OFFICE WAREHOUSE DEVELOPMENT PLAN MINOR AMENDMENT

9495 PEACEFUL VALLEY ROAD
COLORADO SPRINGS, COLORADO 80925

Amendment

SITE /LANDSCAPE PLAN

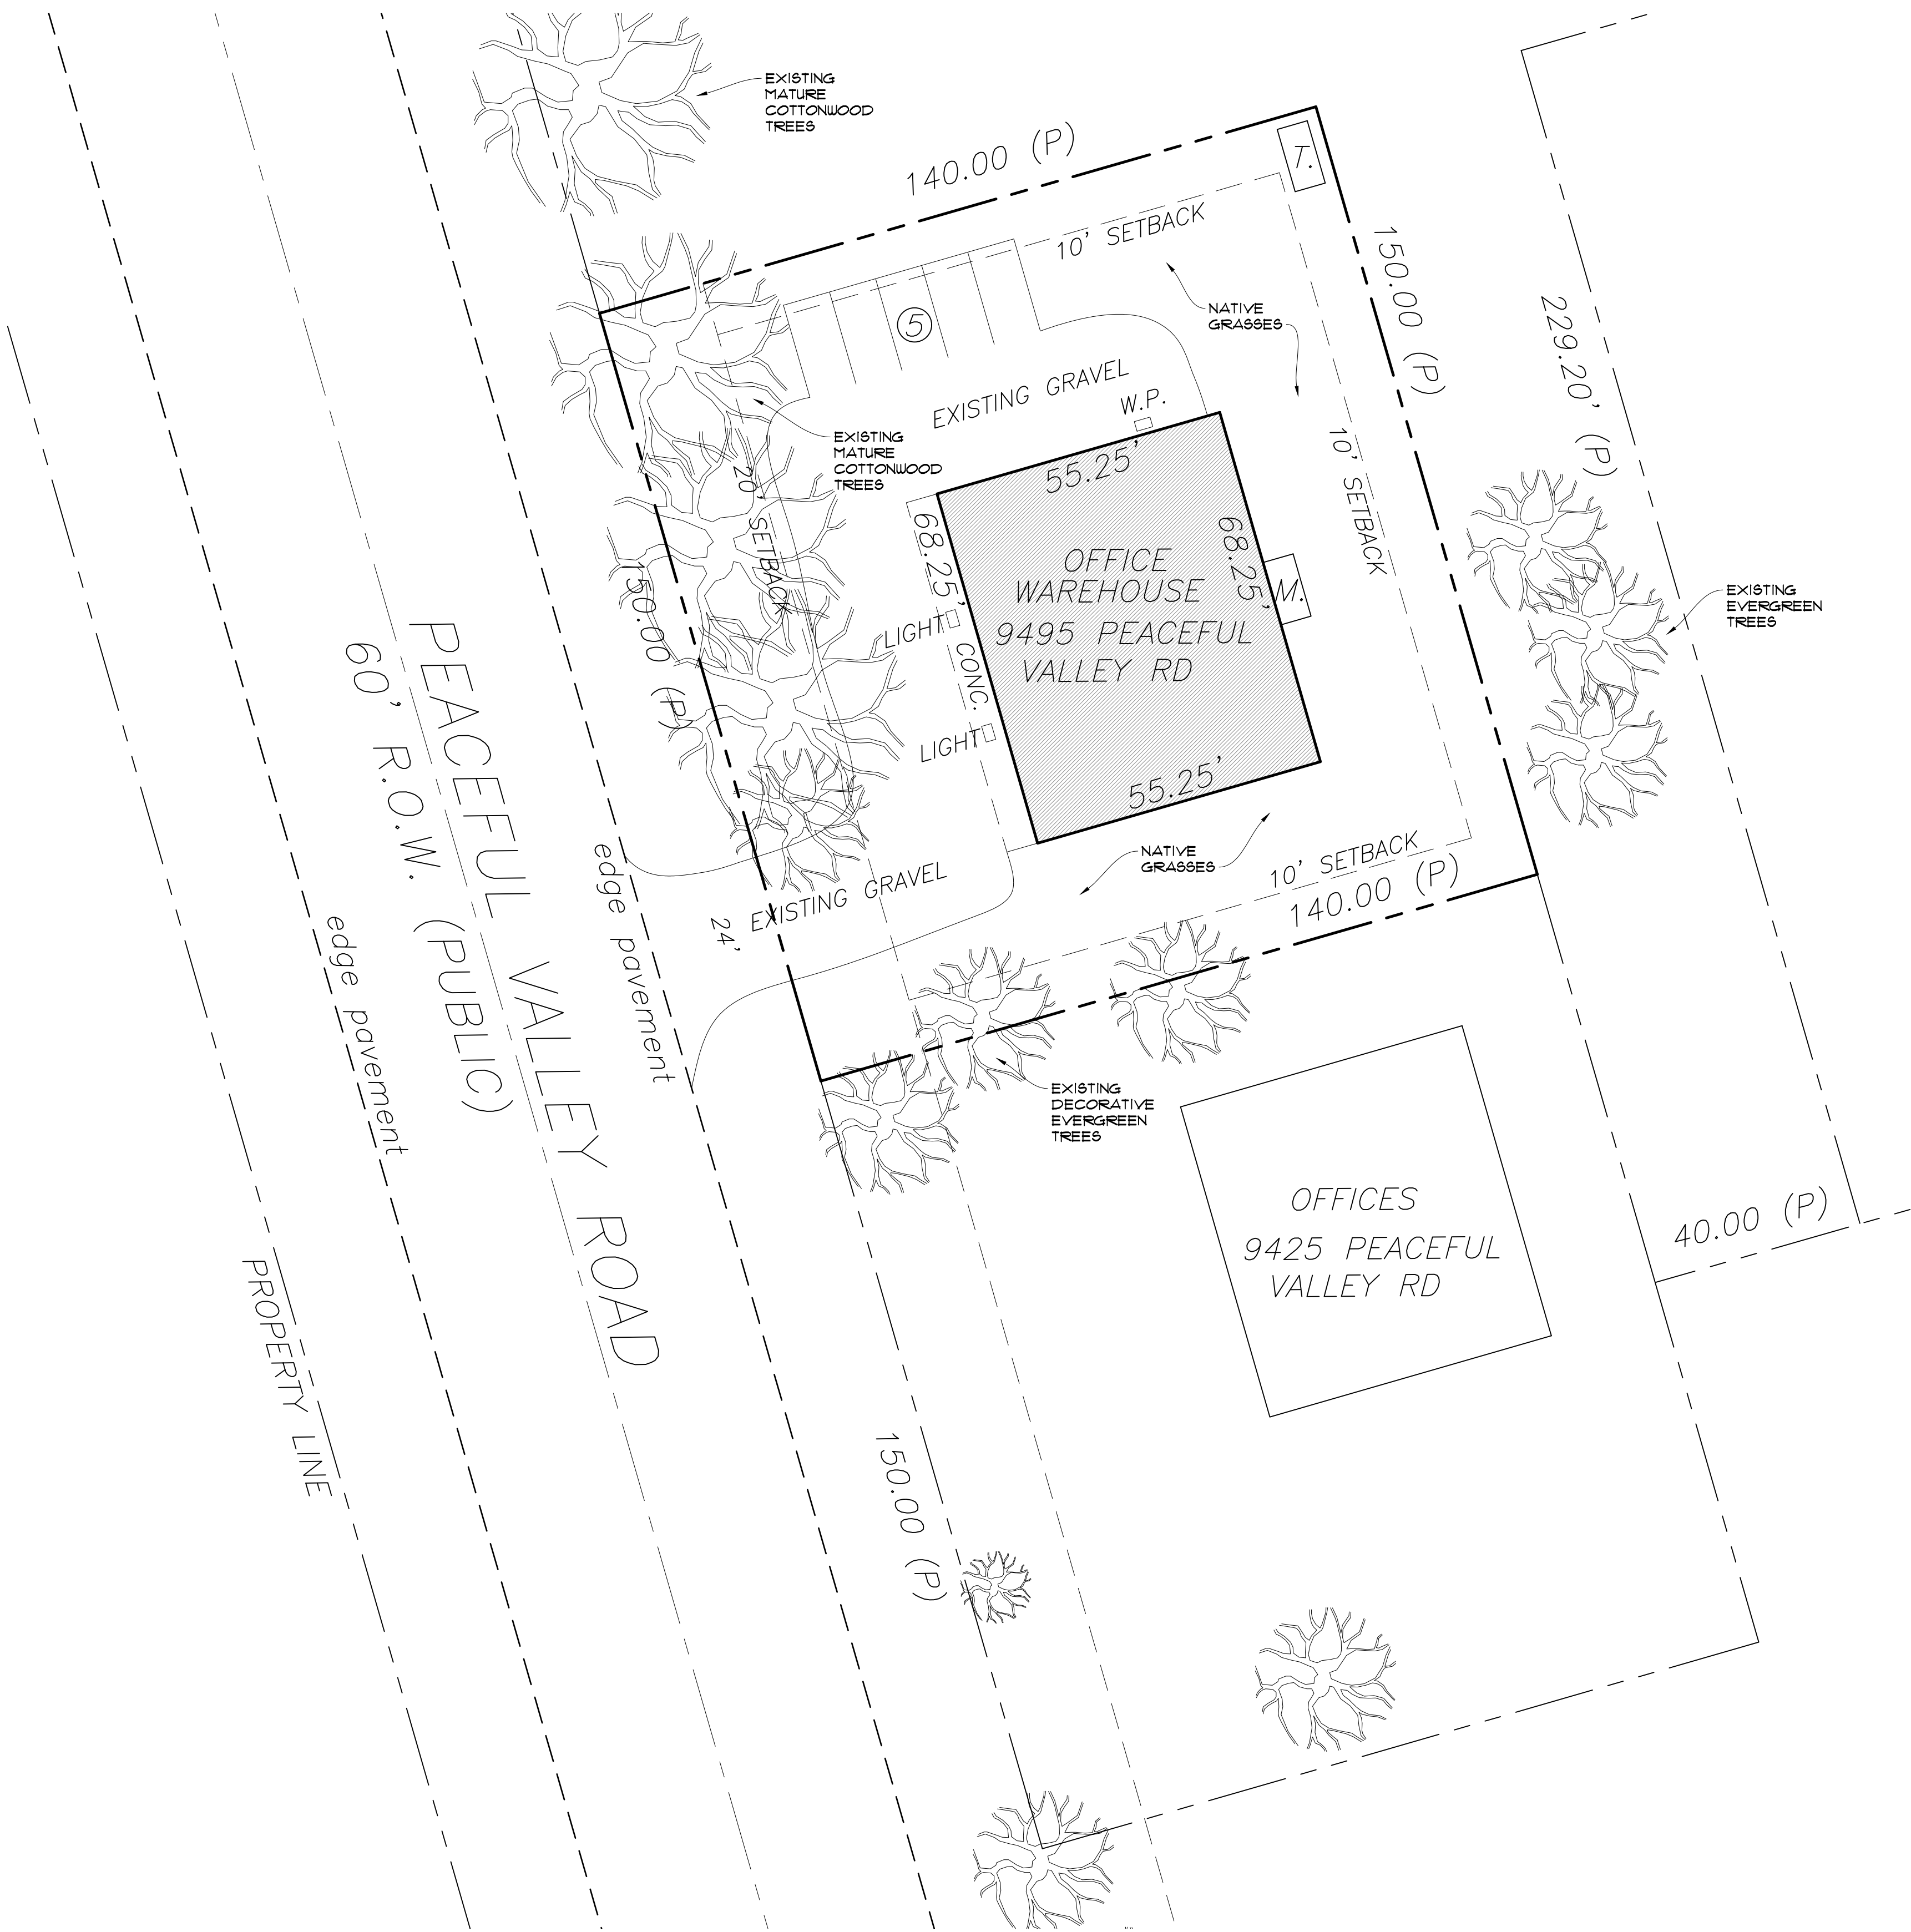
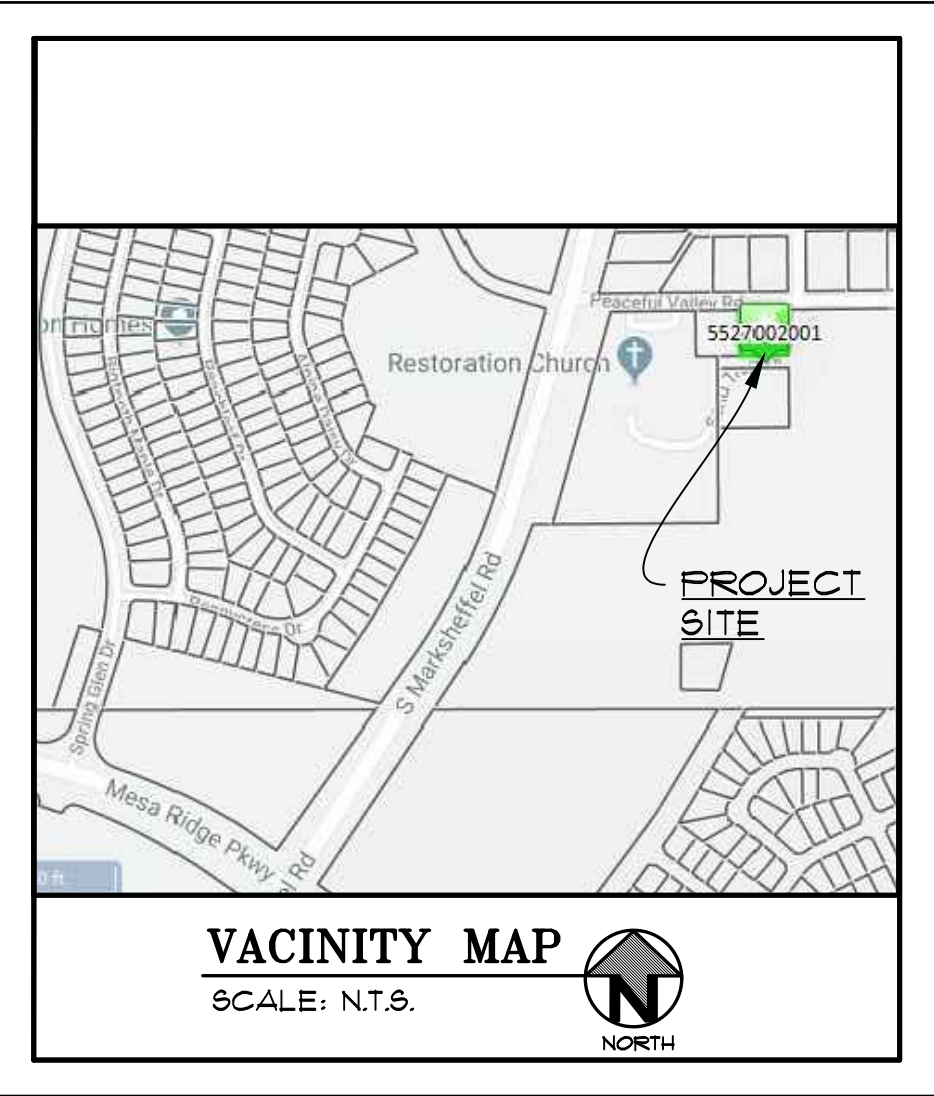
Must be in view accessible space. Depict dimensions on detail and on site development plan.

Screening for parking should be evergreen and needs to reach a height of 3' at maturity

Calculate internal landscaping proposed or existing? Letter of intent must indicate grasses instead of shrubs.

Show screening detail on site development plan
